## About the application

Application number: 2021/93565	
What is the application for?:	Removal of condition 5 (Construction Method Statement) on previous permission 20
Address of the site or building:	Land Adjacent, Hazeldene House, Stoney Bank Lane, Thongsbridge, Holmfirth, HD9 7LZ
Postcode:

Description: **PROPOSED CONSTRUCTION MANAGEMENT PLAN**

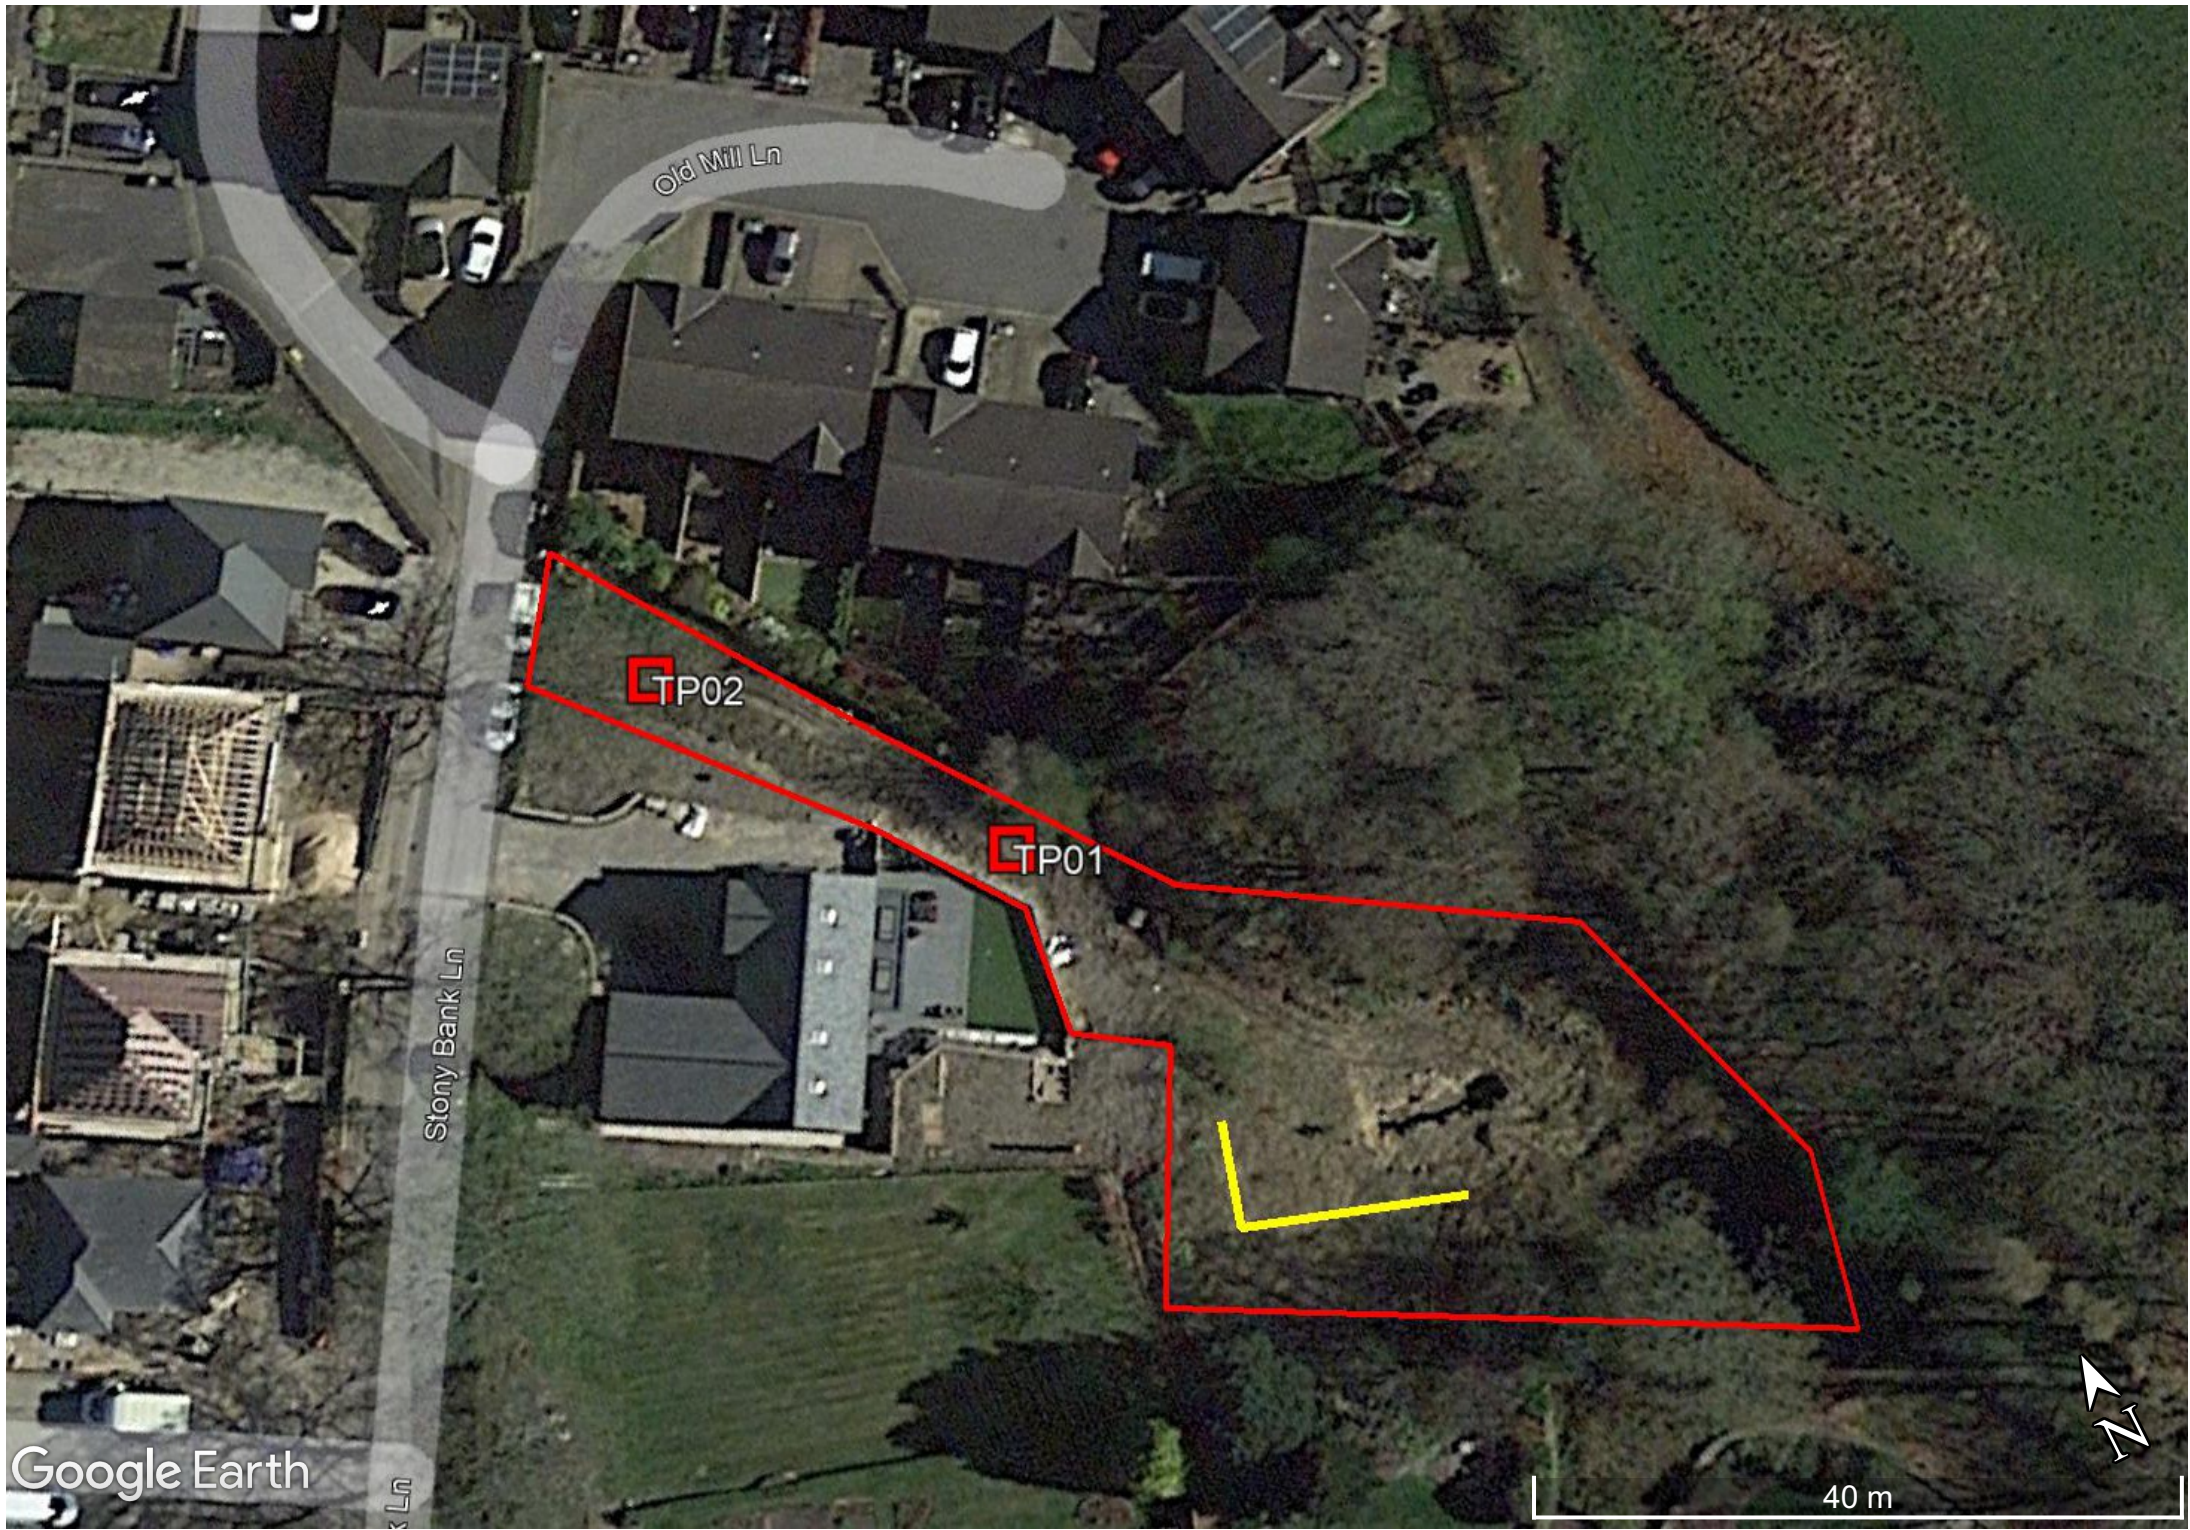
Type of comment: An objection	
Do you wish your comments to be published on the website anonymously?	Yes
<p>At this time there is insufficient information in the construction management plan as well as inaccuracies for this to be considered acceptable.</p> <p>No information has been provided to state how the TPO on the tree to the entrance will be managed and preserved or in regards to any other trees that would be impacted by this plan.</p> <p>In regards to working hours, the hours detailed in the construction management plan are different and exceed those in the original application.</p> <p>The use of more wagons will mean an increase in noise levels for a greater period of time which will impact local businesses as well as residents impacting people livelihood.</p> <p>The access routes for volume of traffic as well as a result of moving to smaller wagons is not clear. Stoney Bank Lane is a single lane with issues in respect to the overall width and condition of the road, and is also not gritted or maintained during winter. A high volume of construction traffic could cause series disruption if not accidents and damage to property which occurs during the winter when vehicles loose control on poorly maintained roads. The weigh and size of these vehicles could have catastrophic consequences to both the highway and current residents properties and no consideration is currently made for this.</p> <p>In respect to removal of materials it is stated that this will be minimal, however previous forestry reports have stated that the area in question suffers from Japanese Knotweed infestation. I see no mention of this or the required removal to standards, and the dispersal of infected material will have catastrophic consequences on the local surrounding area. Further information should be sought and confirmed around this should the wagons be driving in and out of contaminated land. In this instance a wheel wash will be insufficient as this will simply wash contaminated material into the river at the bottom causing further spread and environmental damage.</p>

In respect to the comment around no notable works that would cause significant noise pollution, this does not feel either a true or fair statement. It is currently stated (with no evidence submitted) that the land is believed to sit on bedrock. This needs to be confirmed with detailed engineers surveys which again have not been supplied at this time. Should this be the case, it is currently estimated that up to 5000 tonnes of material (bedrock) will need to be dug out and smashed up by machinery on site (this is currently excluded from the submission) and if this is the case, then there will be excessive noise levels repeatedly for months whilst breaking rock with large plant.

In short, I find this current proposal to lack detail where required around suitable safety measures, and management of ongoing construction as well as damage to the environment and is also not in line with the previous applications.

It is also know that running through this site are large soakaways that drain water from Holmfirth High School, and the football fields know as little wembley. This high volume of water (particularly during winter and wet periods) that passes through the site needs to be taken into consideration on the impact and flood potential that could occur due to the construction of this accessway and ongoing construction works.
